<b>Application Reference Number:</b>	2025/0659
--------------------------------------	-----------

<b>Application Type:</b>	Variation of Condition(s)
--------------------------	---------------------------

<b>Proposal Description:</b>	Variation of condition 2 (amended garage design) of application 2024/0050 (Removal of existing extension and detached garage and erection of a detached double garage and reposition gates)
------------------------------	---------------------------------------------------------------------------------------------------------------------------------------------------------------------------------------------

<b>Location:</b>	6 Eaming View, Barnsley, S71 1DJ
------------------	----------------------------------

Project:	PROPOSED GARAGE 6 EAMING VIEW BARNSELY, S71 1DJ	Client:	
Drawing Title:	PLAN AND ELEVATIONS AS PROPOSED	Date:	OCTOBER 2025
		Scale:	1:50 @ A1
		Ref.:	25-02
		Dwg. No.:	04
		Rev.:	A

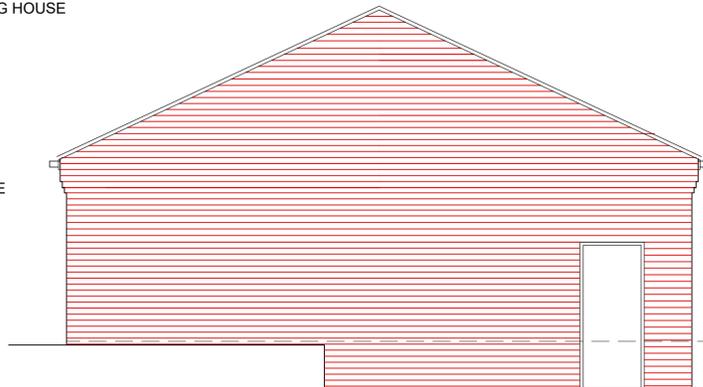
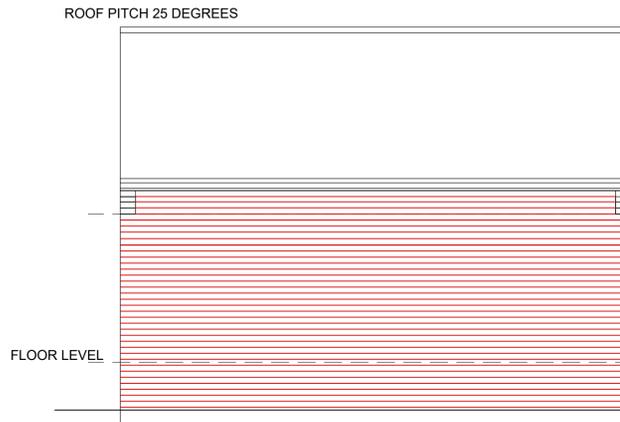
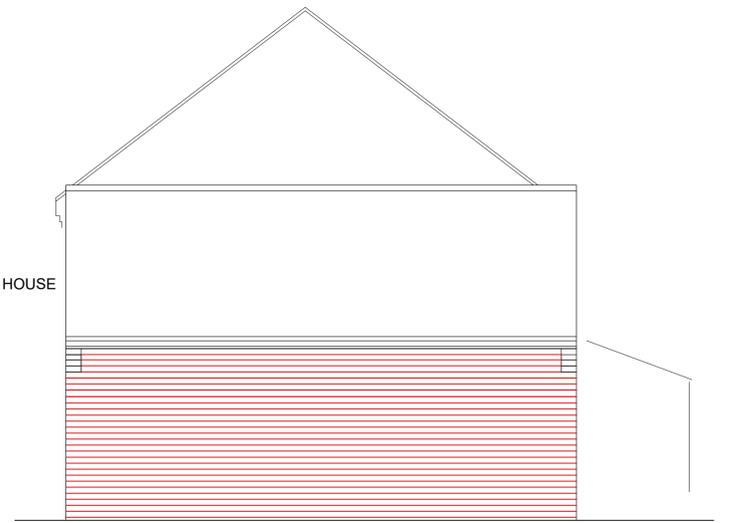
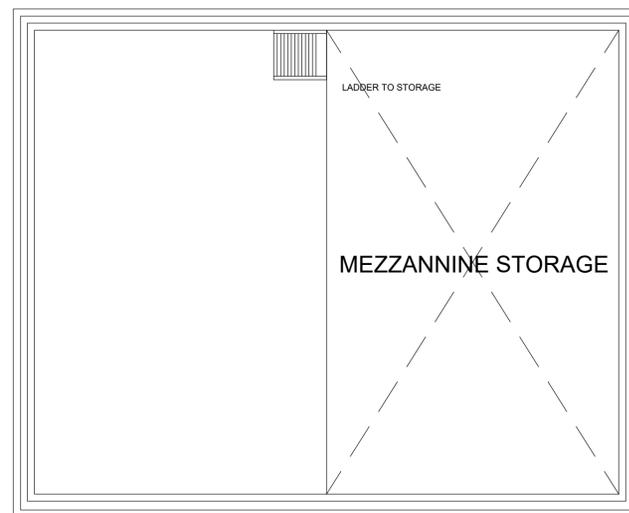
The SPD states that *“detached garages and outbuildings should be single storey structures and the eaves height should not normally exceed 2.5 metres from ground level, whilst the ridge height should not exceed 4 metres”*. The proposed garage has a pitched roof with a maximum height of 4.75 metres and an eaves height 2.55 metres which exceeds with the above recommendation by 0.75 metres in regard to the total height.

Although exceeding the above recommendation the SPD also states that *“in some circumstances (e.g. where the garage is set within a large curtilage) it may be possible to utilise the roof space for ancillary accommodation/storage”*. The dwelling is set in a large curtilage with no adjacent dwellings present therefore the addition of the extra roof space from the previously approved application is deemed acceptable in this circumstance. The roof space is specified for storage on the amended plans and is only accessible by a roof ladder not a staircase.

During the course of the application, the height of the garage has been reduced with the total height of the garage now set in line with the eaves height of the dwelling rather than being taller than the eaves. This reduction in height improves the relationship between the garage and the dwelling whilst increasing subservience. Furthermore, with regards being visible from public vantage points due to its siting to the side of the dwelling it would only be highly visible from the car park to the south which is set at a higher land level therefore reducing the visual impact from that viewpoint. This weighs moderately in favour of the proposal.
